From: Ian Stocks [REDACTED] **On Behalf Of** FRS Water and Access
Sent: 14 January 2021 08:54
To: Planning.Responses <Planning.Responses@arun.gov.uk>
Subject: Planning Application consultation - BR/298/20/PL 25 Sudley Road Bognor Regis PO21 1EW

PROPOSED
- SITE PLAN

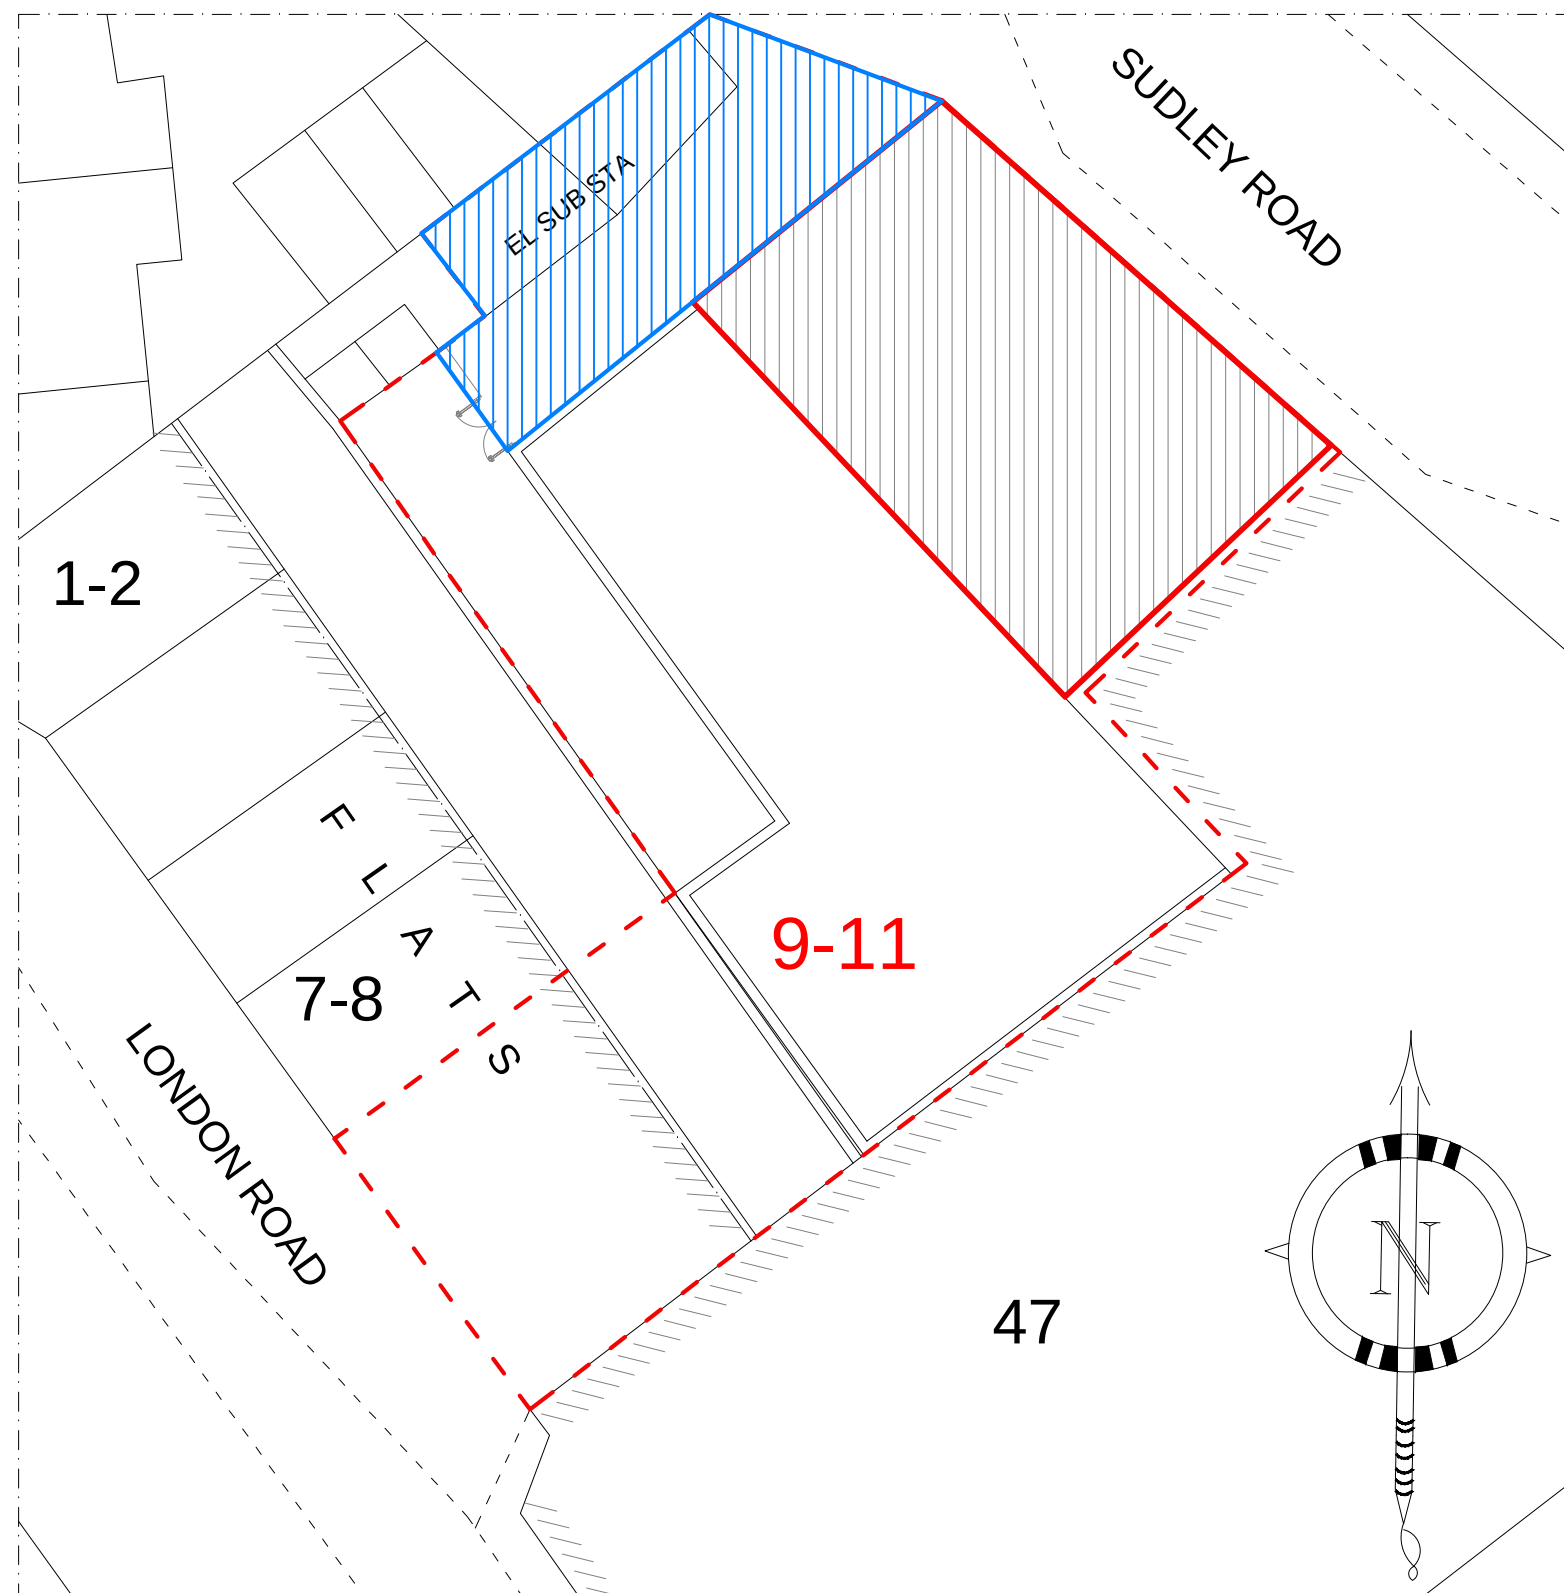
Having viewed the plans for the planning application for the address given above, evidence will be required that all areas of all domestic properties are within 45 metres of a fire appliance in accordance with Approved Document B Volume 1 2019 Edition para 13.1 (page 97); all points inside each dwelling is to be within 45 metres of a fire appliance. This is due to the minimum length of firefighting hose connected to the appliance used to fight fires. Any areas not within the 45 metre distance will need to be mitigated by the installation of domestic sprinklers.
